Consultation Response from KC, Conservation and Design
2021/91871 Land adj, High Street and Challenge Way, Hanging Heaton, Batley
Erection of residential development including access and associated infrastructure
Date Responded: 16/06/21 | Responding Officer: Craig McHugh | Responding Ref: BHS 5/33

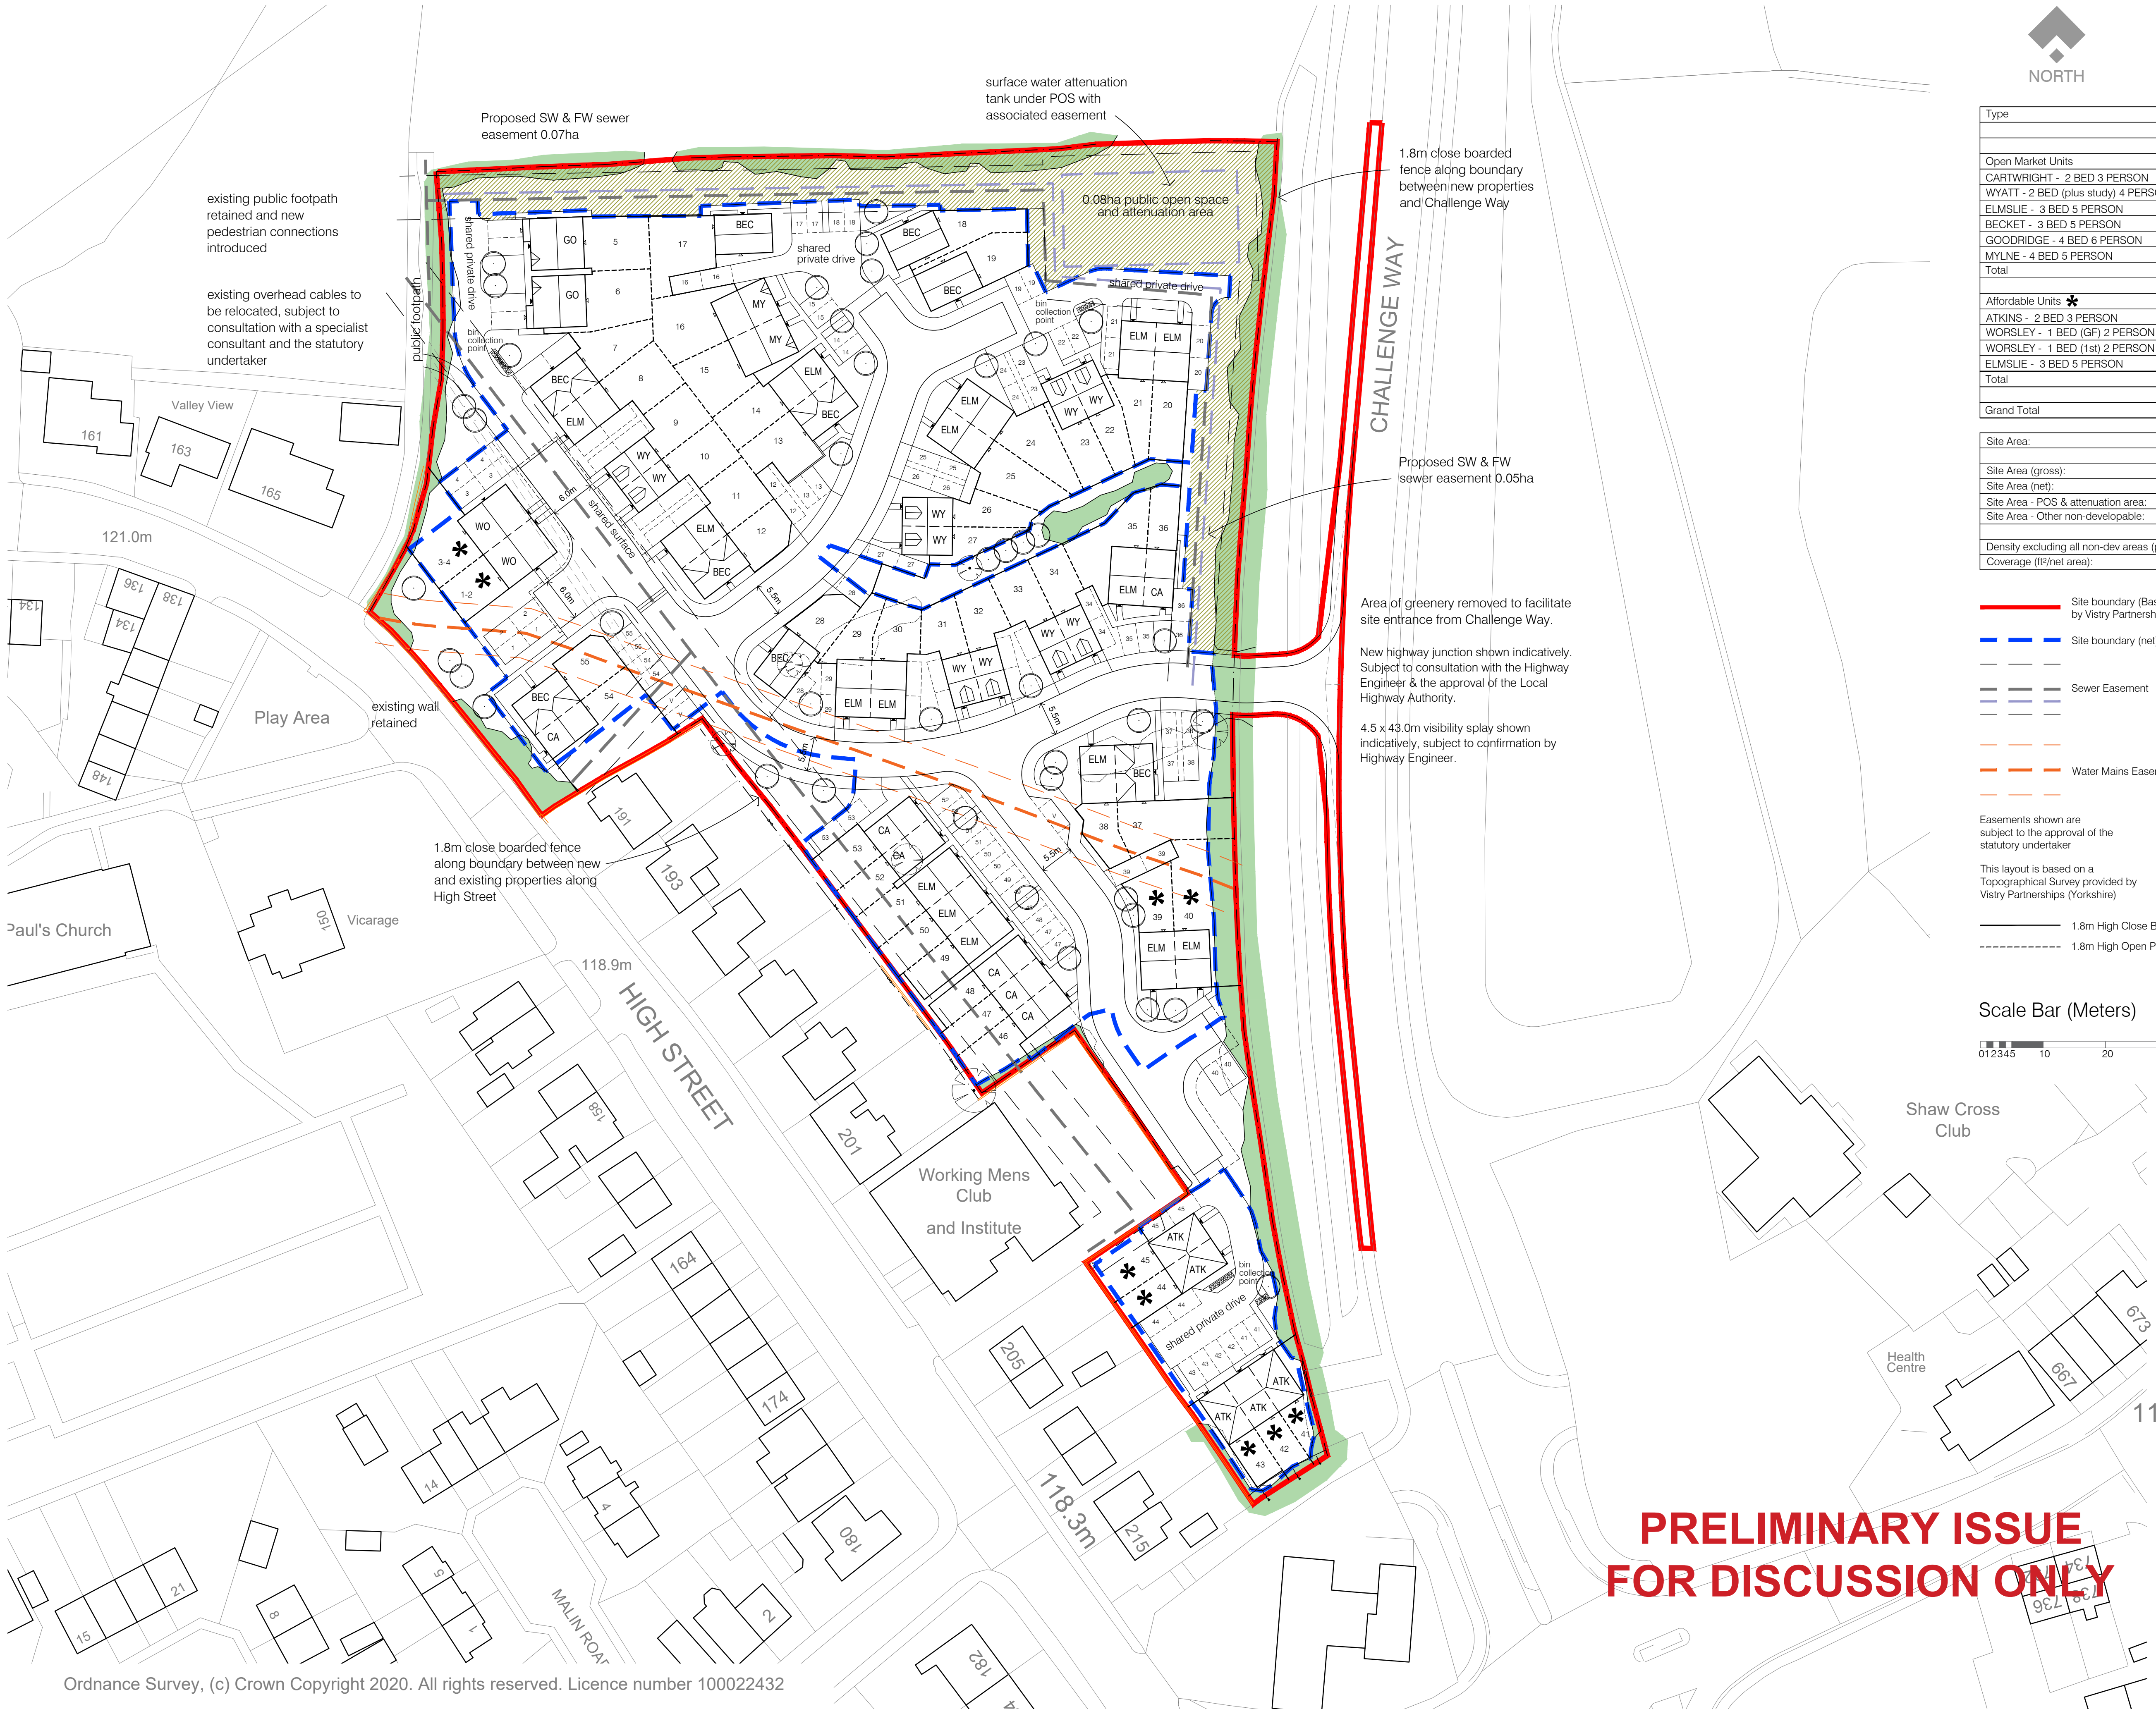
As advised at pre-application stage we should consider the impact of the proposed development on views to and from the St Paul's Church, the Vicarage and School including from the Public Right of Way BAT/45/30 towards these buildings. The submitted Heritage Impact Assessment does not consider views from the Right of Way. The proposed 1.8 metre high timber fences and stone boundary walls (of unspecified height) along the path would likely impede views from the south west end of the path where it meets High Street. This impact should either be considered further in a revised Heritage Impact Statement or the proposals should be amended to maintain the existing boundary heights in this part of the development site.

As advised at the pre-application stage, consideration should be given to revising the layout of the development to retain and restore the field boundary associated with the listed boundary stone (running from south west to north east through the site) this would be considered a heritage benefit when weighing any harm from the proposals under paragraph 196 of the NPPF

As advised at the pre-application stage the listed boundary stone should be marked on all relevant plans submitted for planning and on any construction issue drawings. A method statement will be required setting out measures to protect it during the construction phase of the development, particularly during works to the boundaries of the development on High Street. The boundary stone is only shown on some planning drawings. This small object is very vulnerable to damage during construction works, whether that work requires planning permission or are works to maintain and repair the existing wall. To protect it a condition should be applied.

- The layout and boundary treatments of the development where the Right of Way BAT/45/30 meets High Street should be revised to maintain views from the Right of Way towards St Paul's Church and the historic buildings within its curtilage
- The layout of the development should be revised to repair or restore the field boundary historically associated with the grade II listed boundary stone
- A condition is required as follows to protect the grade II listed boundary stone:
